Your ref:
Our ref: 22/01034/F
Please ask for: Mrs Lesley Raby
Direct dial: 01553 616818
E-mail: borough.planning@west-norfolk.gov.uk

Details: **Erection of detached double car port with gym and study area at Little Haven
Ling Common Road North Wootton Norfolk PE30 3RE**

I have received a planning application as detailed above but cannot process it until I receive some more information:

Drawing 02 - July 2022
EXISTING SITE PLAN

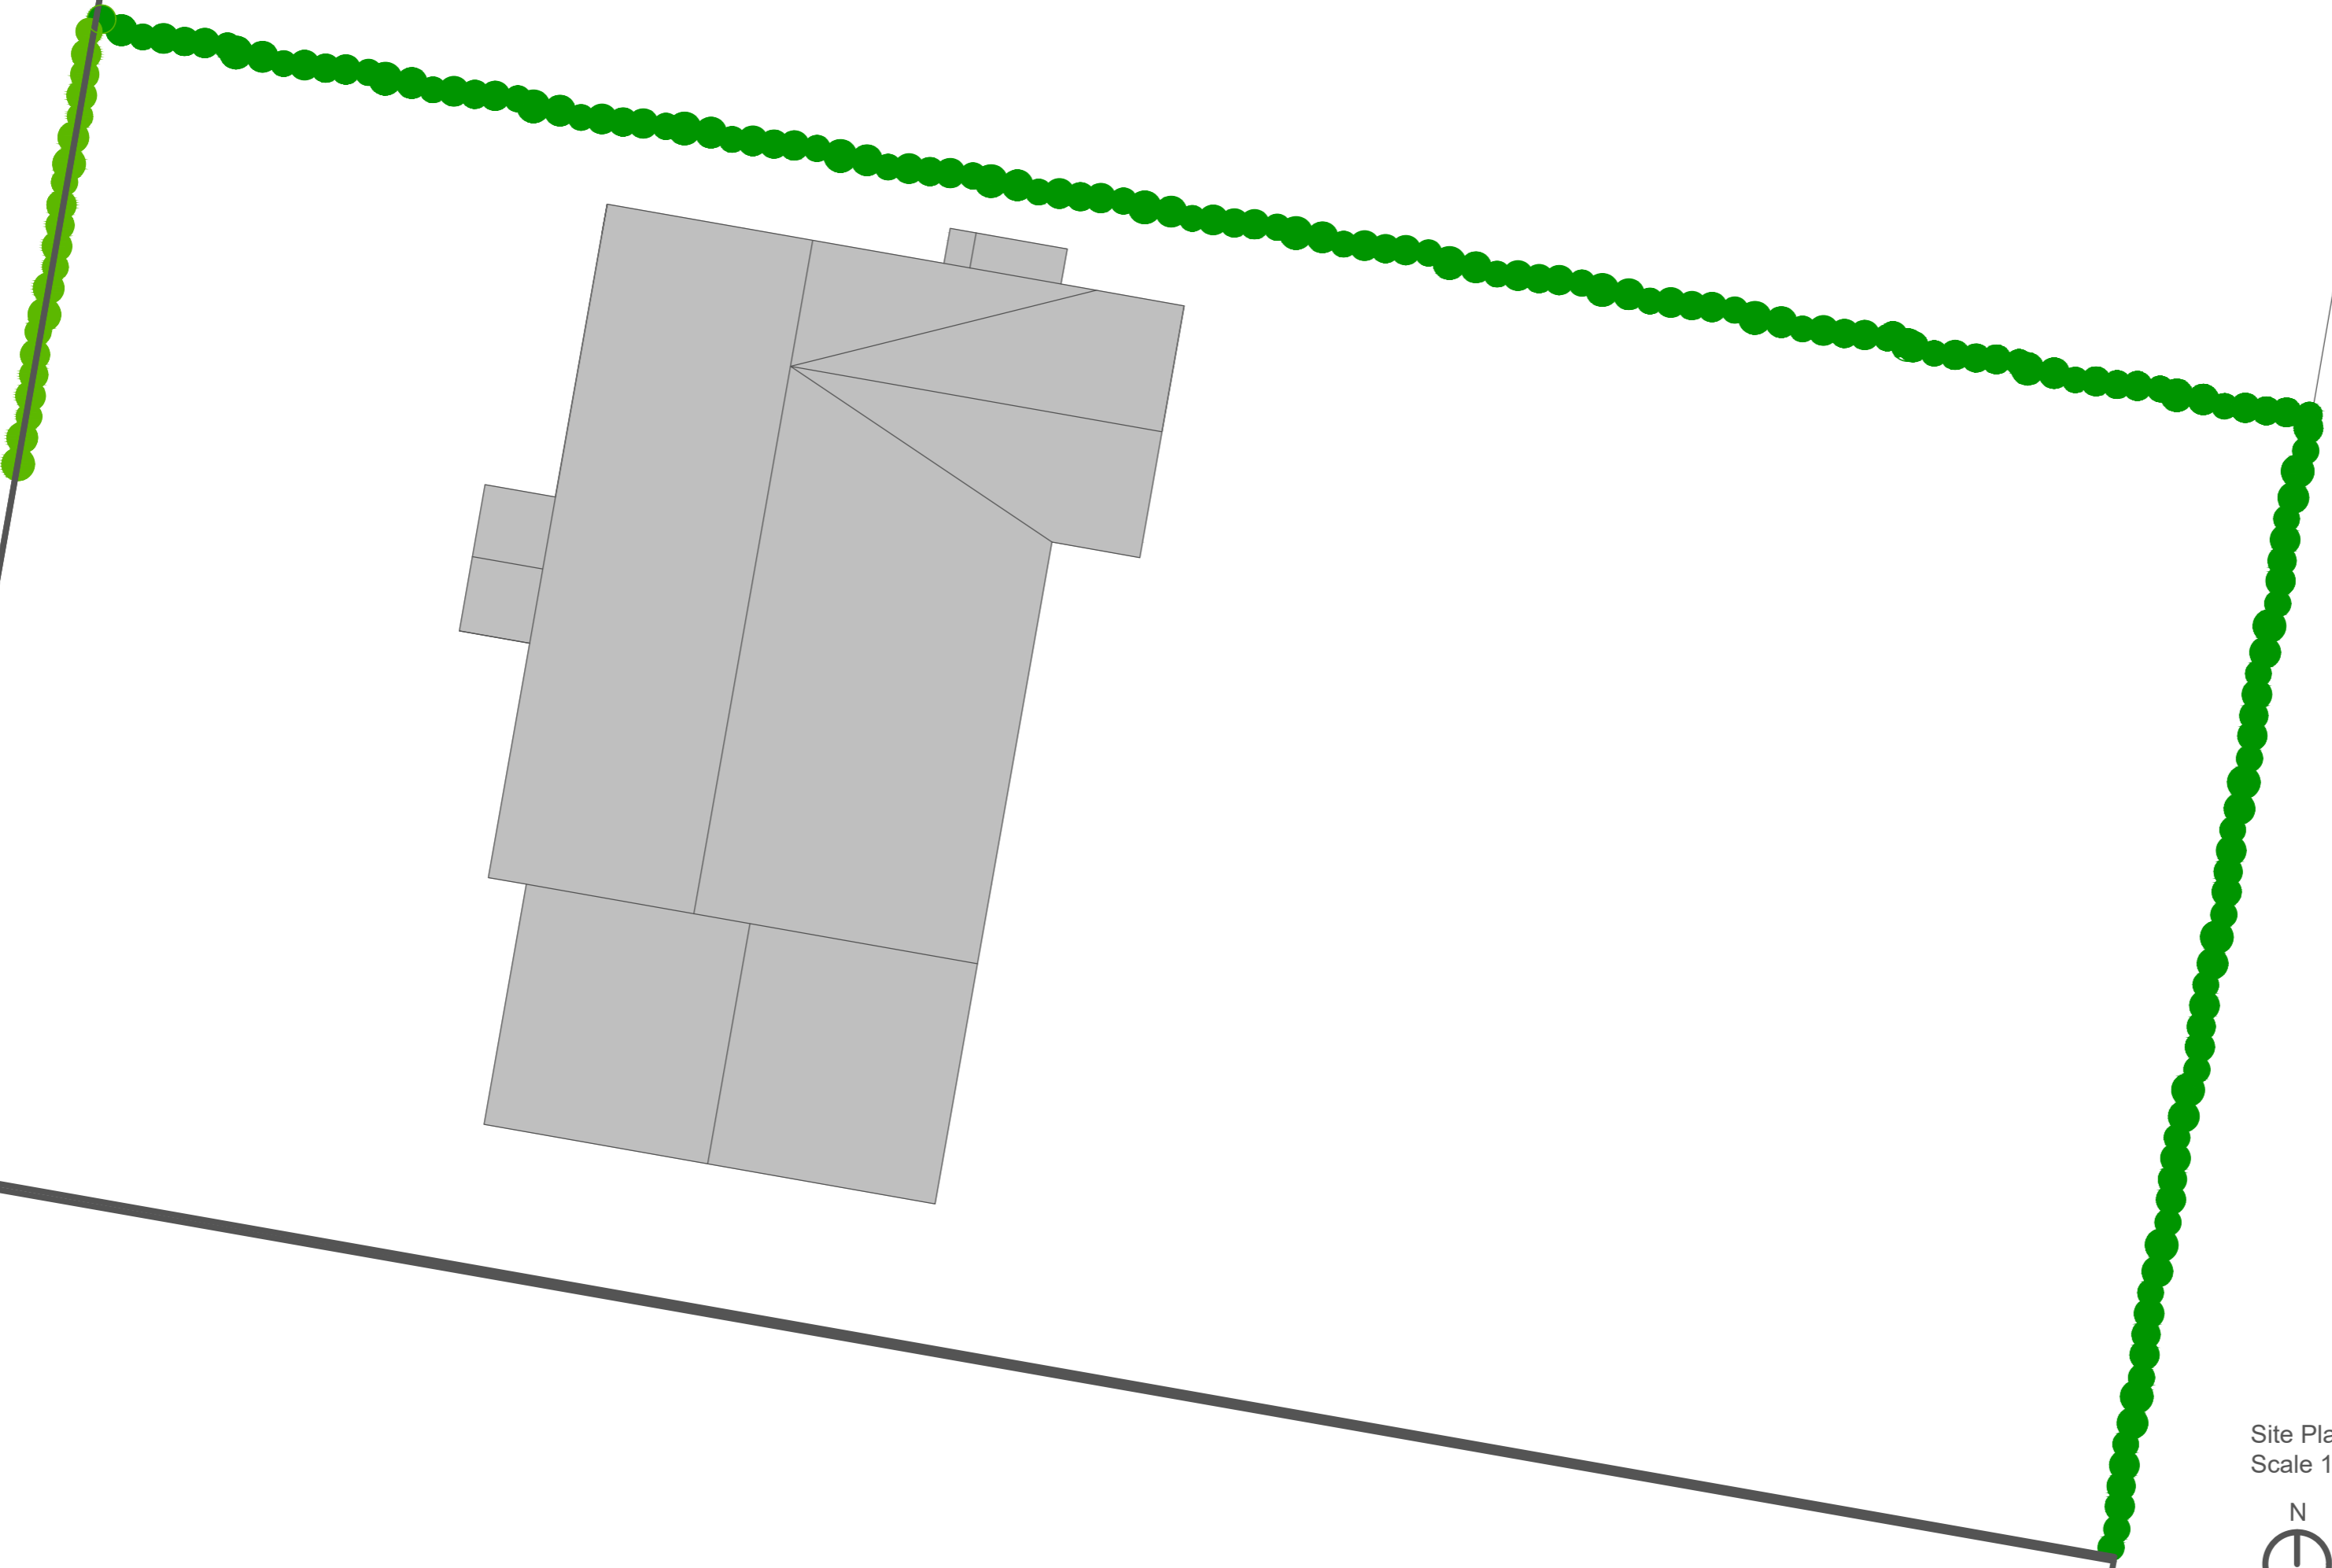
The existing block plan shows the North boundary at 30.8m and along the road front boundary 19.3m

These plans should all scale the same measurements- please check and amend as necessary.
